## WEST SUSSEX COUNTY COUNCIL CONSULTATION

| <b>LOCATION:</b>                | Boundary wall to Nyton House, Nyton Road,<br>Westergate, PO20 3UL                                                                                                                                          |
| <b>SUBJECT:</b>                 | AL/10/22/PL<br><br>Part demolition of boundary wall to form new access to existing site. This application is in CIL Zone 3 (zero rated) as other development and affects the setting of a Listed Building. |
| <b>RECOMMENDATION:</b>          | More Information                                                                                                                                                                                           |

Site Plan
showing proposed works

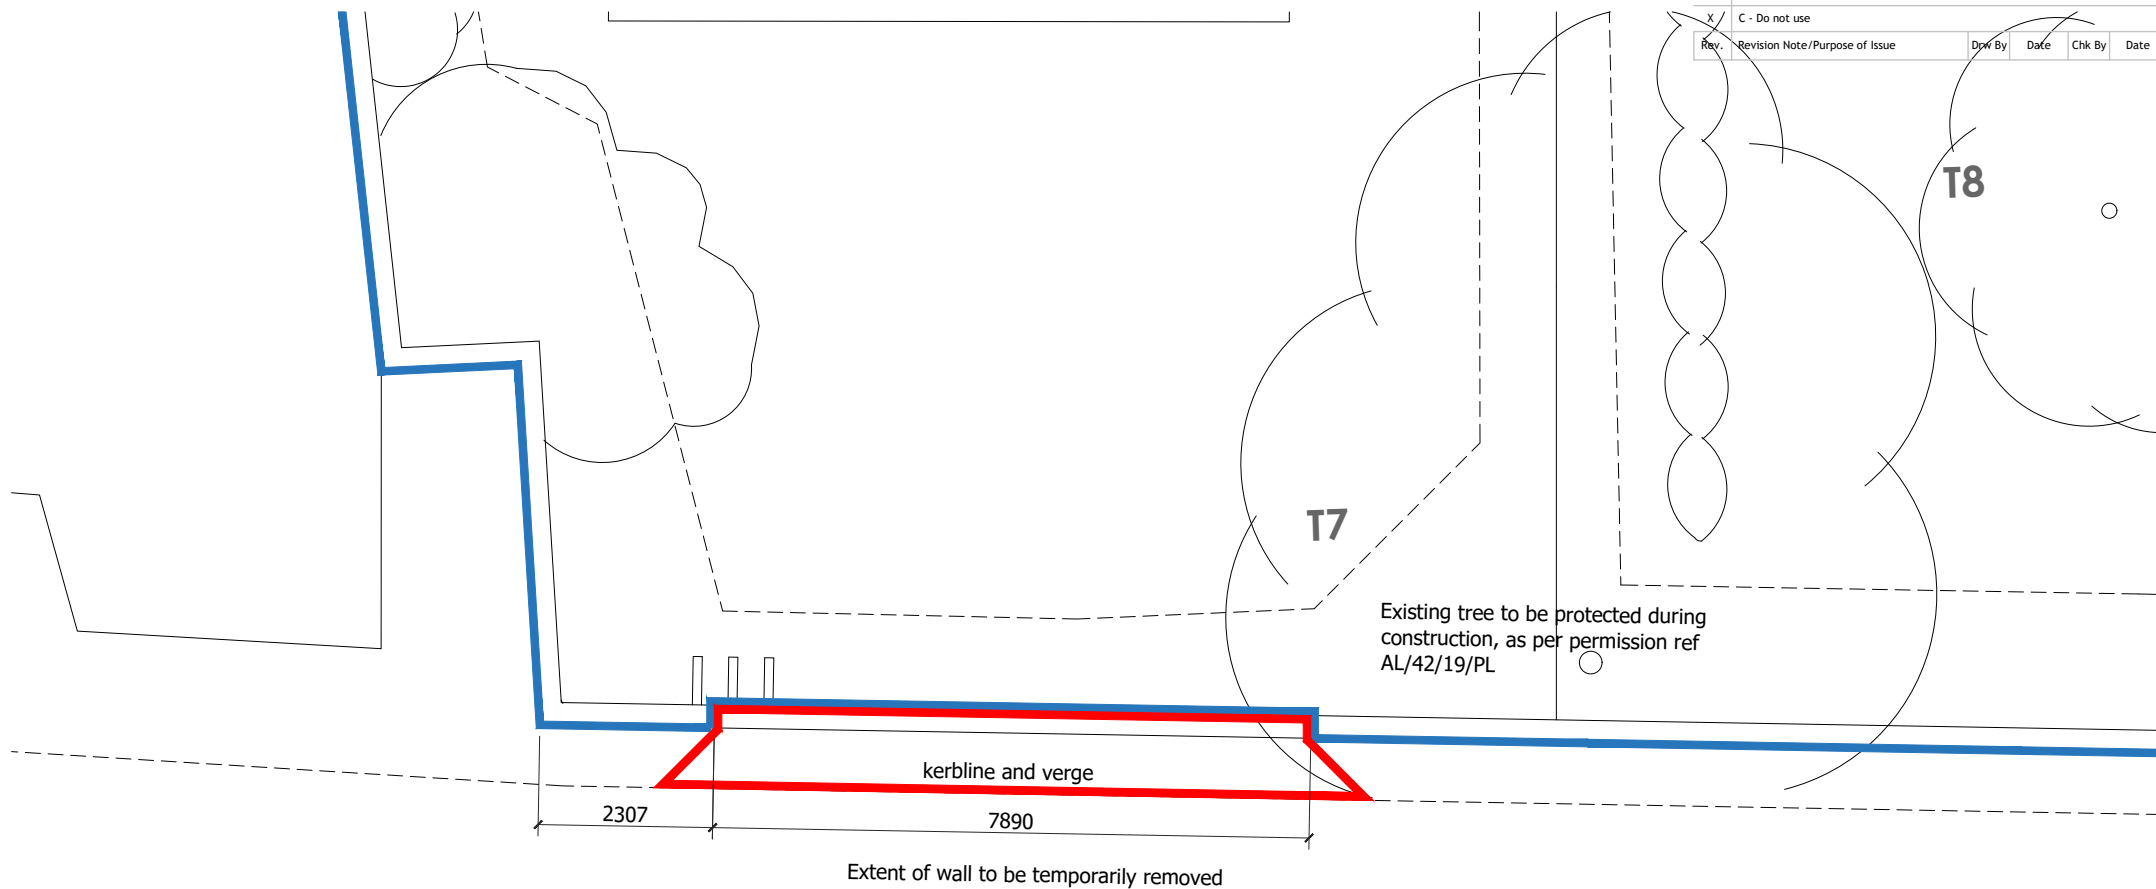
The submitted plans details that the access will be afforded visibility splays of 2.0 x circa 6.5 metres. Nyton Road at this point is subject to a 30-mph speed limit, though given the nature of the road it is not unreasonable to consider that actual road speeds may be above the posted speed limit.

Notwithstanding the above a new access with 30 mph approach speeds would require visibility splays of 2.4 x 43 metres. Therefore, the proposed access, while only temporary, is going to be afforded significant substandard visibility splays.

Are there any reasons why the existing access arrangement are not being utilised for the construction phase?

What scope if there to provide improved visibility splays? Will any additional mitigation measures be put into place?
